CITY OF ALBUQUERQUE

January 31, 2023

Re: **Dutch Bros. Coffee NM0203, TCL**
220 98th Street NW
Albuquerque, NM
Traffic Circulation Layout
Submitted January 30, 2023
PE's Stamp 12/2/8/2022 (HT#K09D048B)

1 SIGN SITE PLAN BY OTHERS - REFERENCE ONLY
NOT TO SCALE

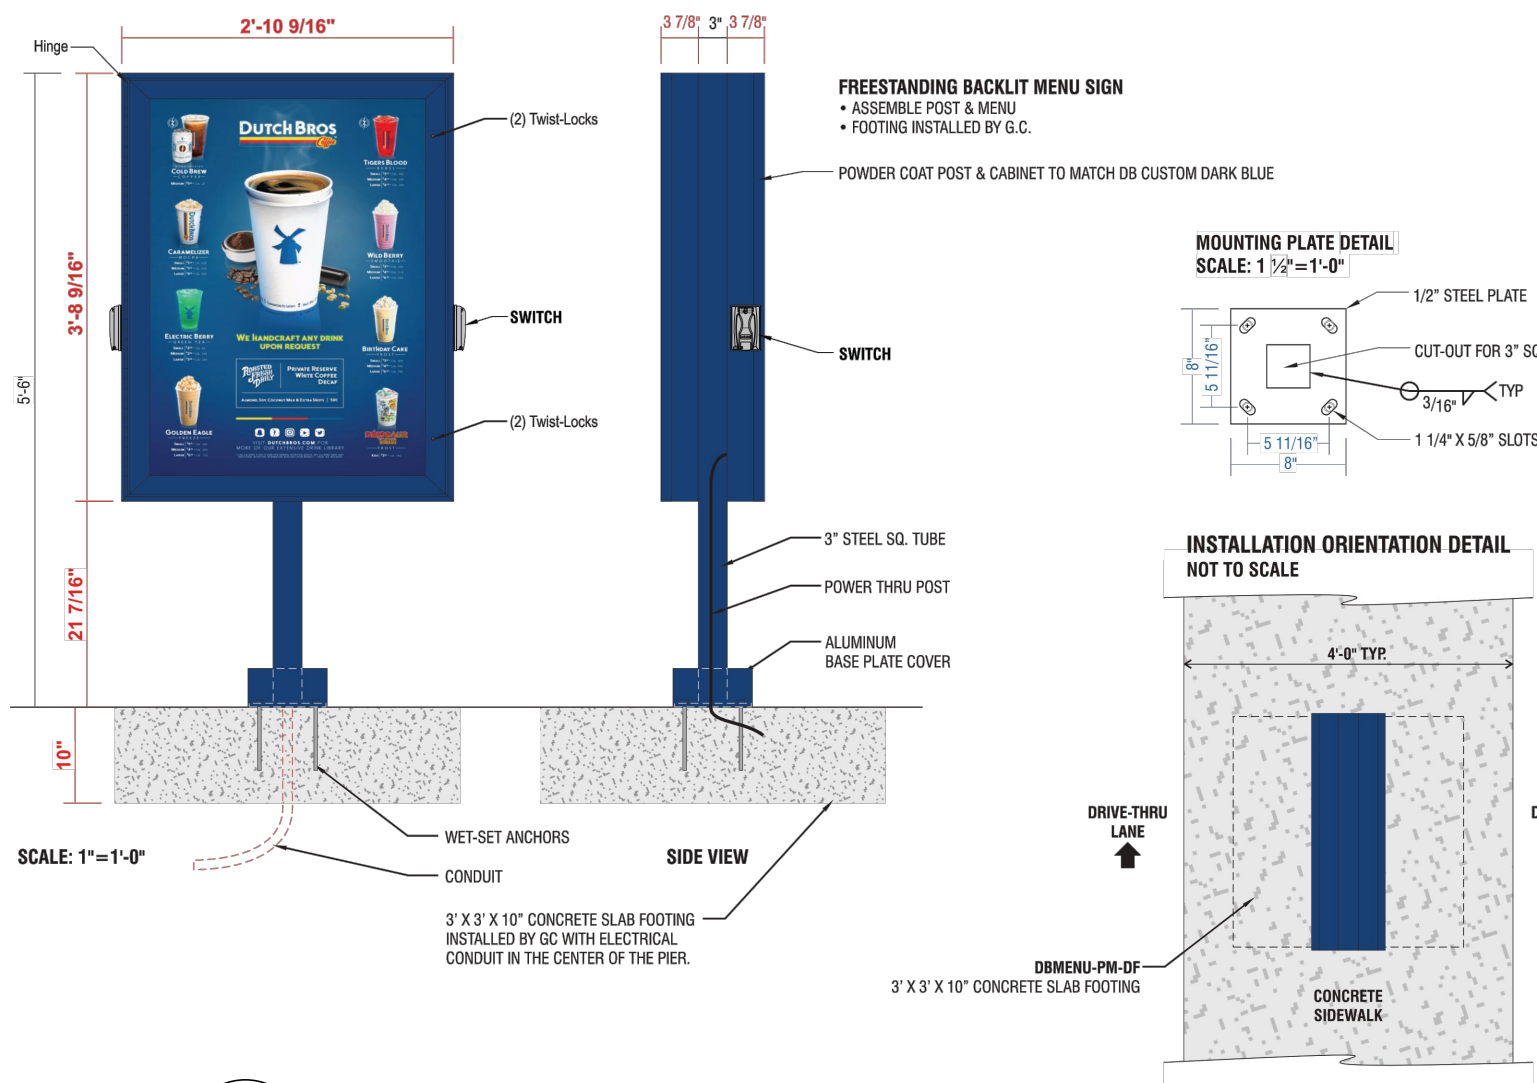
1. Add a Do Not Enter sign (R5-1) to be placed at the drive through exit lane. Include the sign face details in the plans.
2. Provide approval from the Fire Marshal and Solid Waste.
